From: Martyn White
Sent: 22 October 2021 14:06
To: Maria Tomalova
Subject: RE: Kents Farmhouse at Climping CM/49/21/DOC

Re Kents House, Climping CM/49/21/DOC

Condition no 2 - The drawing for the window sections has come from the joinery company, but they have been instructed following the Discharge of this Condition that all window glazing must be the 4 x 4 x 4 design and not 24mm

Drawing Title
**WINDOW AND DOOR
DETAILS**

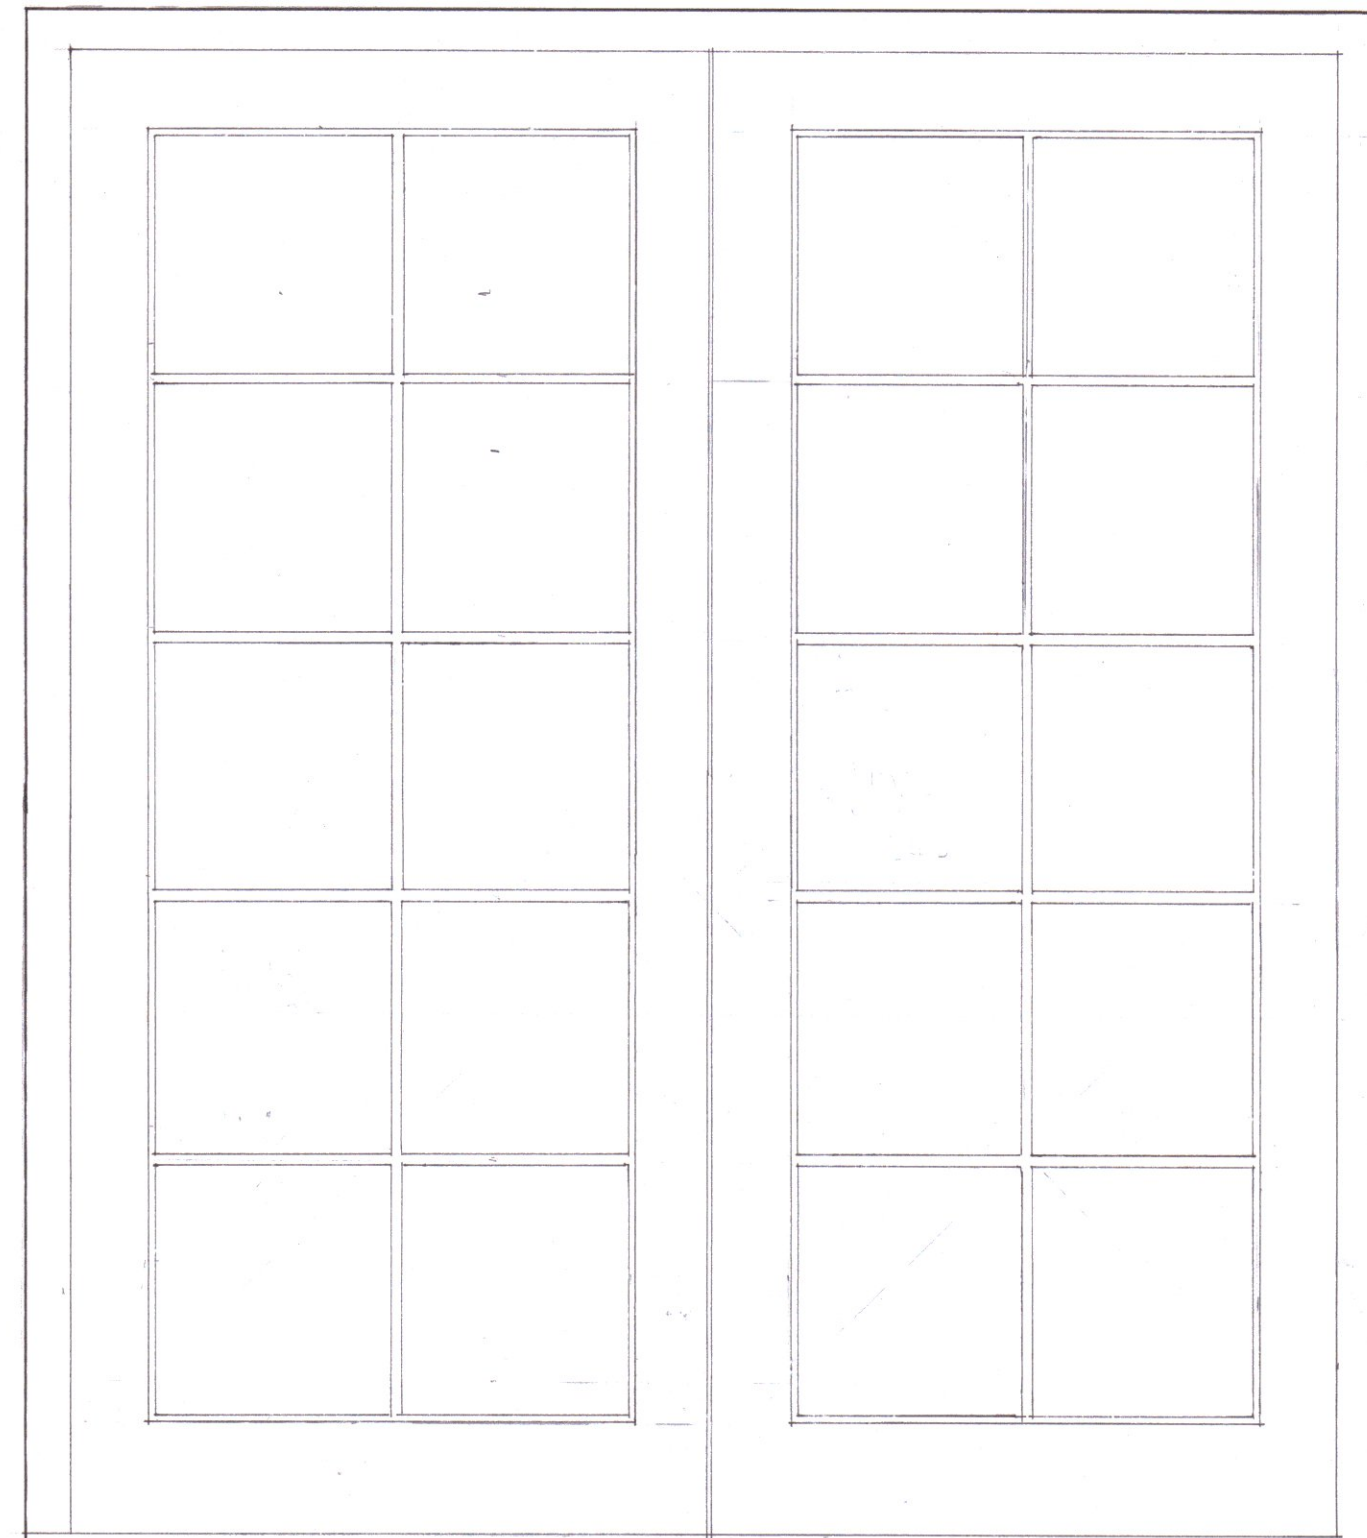
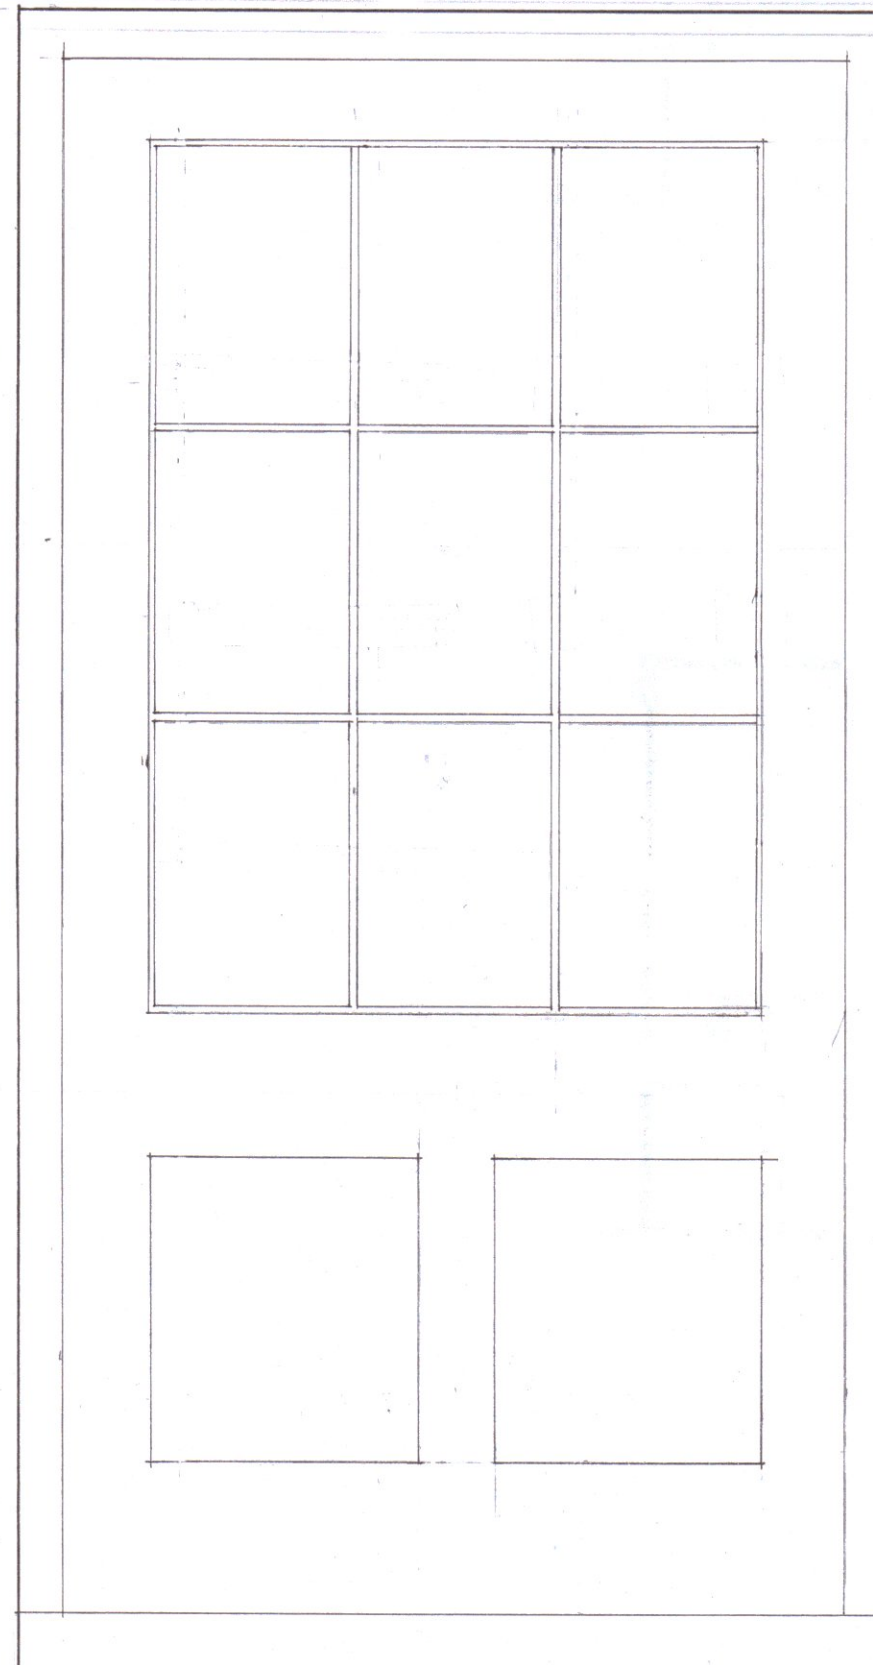
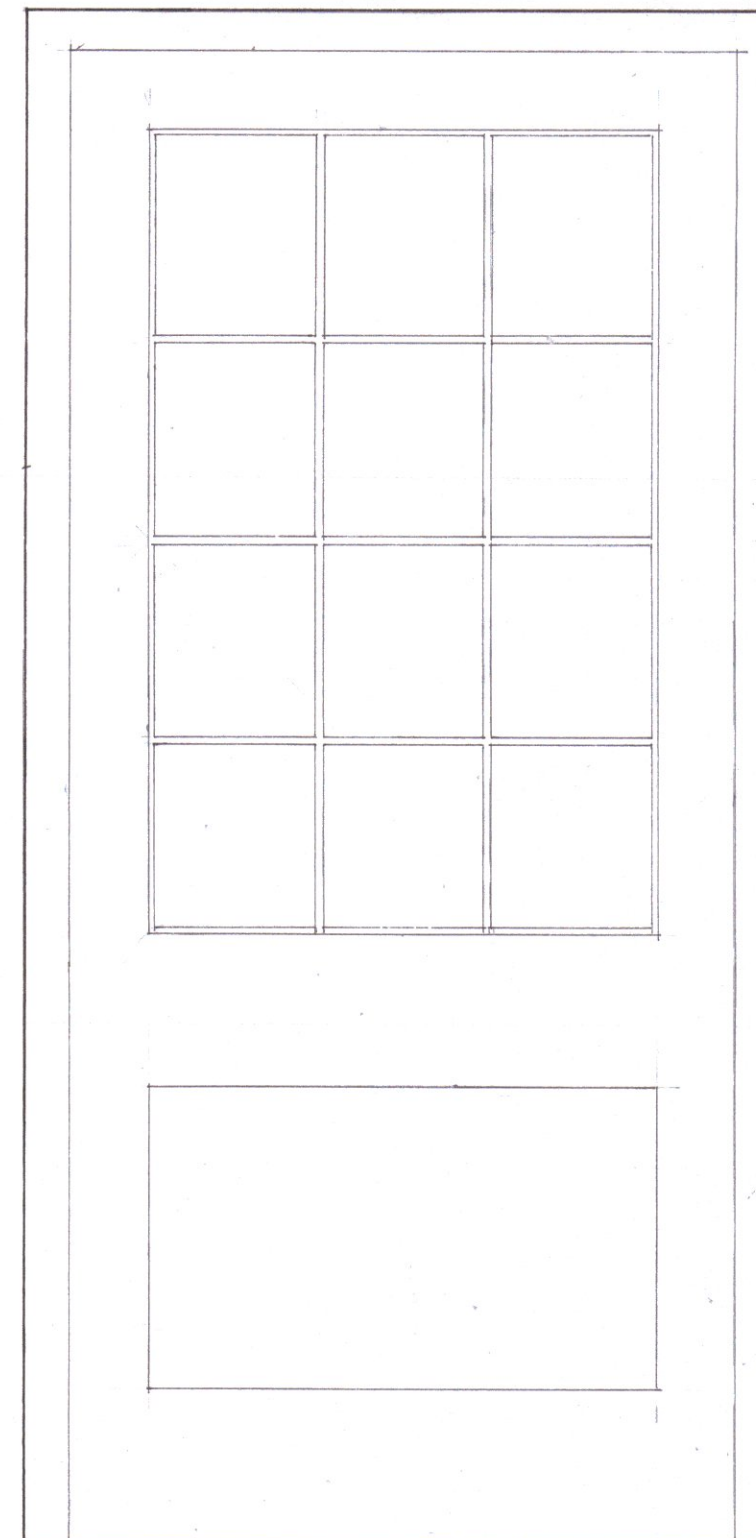
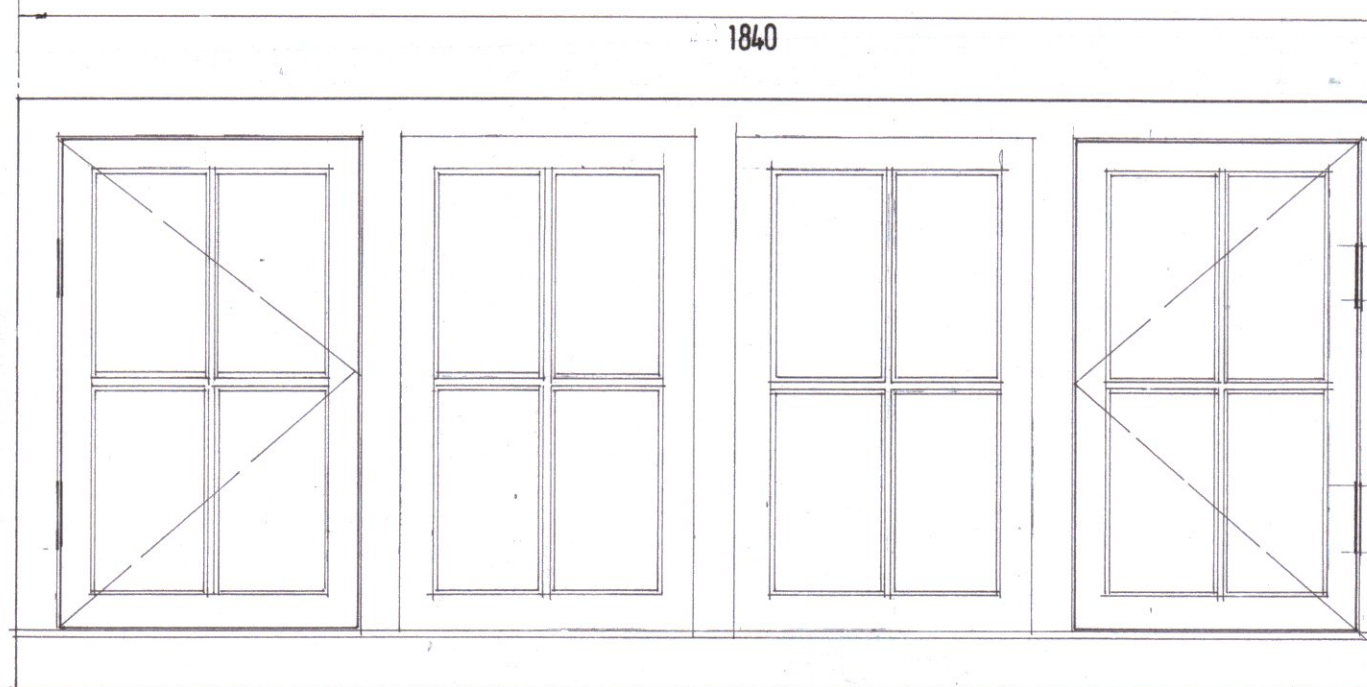
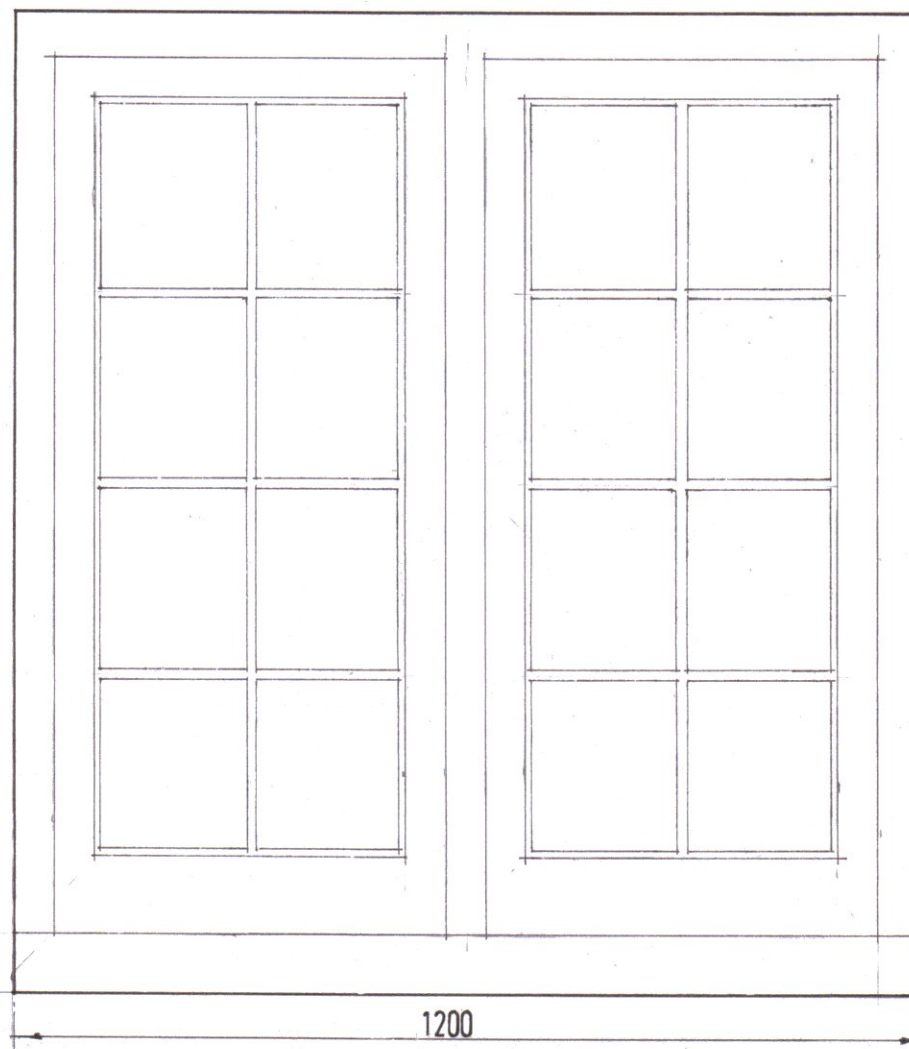
The window bars are to be a match to the glazing bars elsewhere in the house they ~~are to~~ frame up each pane of glass i.e. not applied or stuck on imitation glazing bars

In summary the windows, doors and their various sections are to match the period of the house

I am sorry that this is late coming to you. Yes, I am happy with the response from the agent and the condition can be discharged.
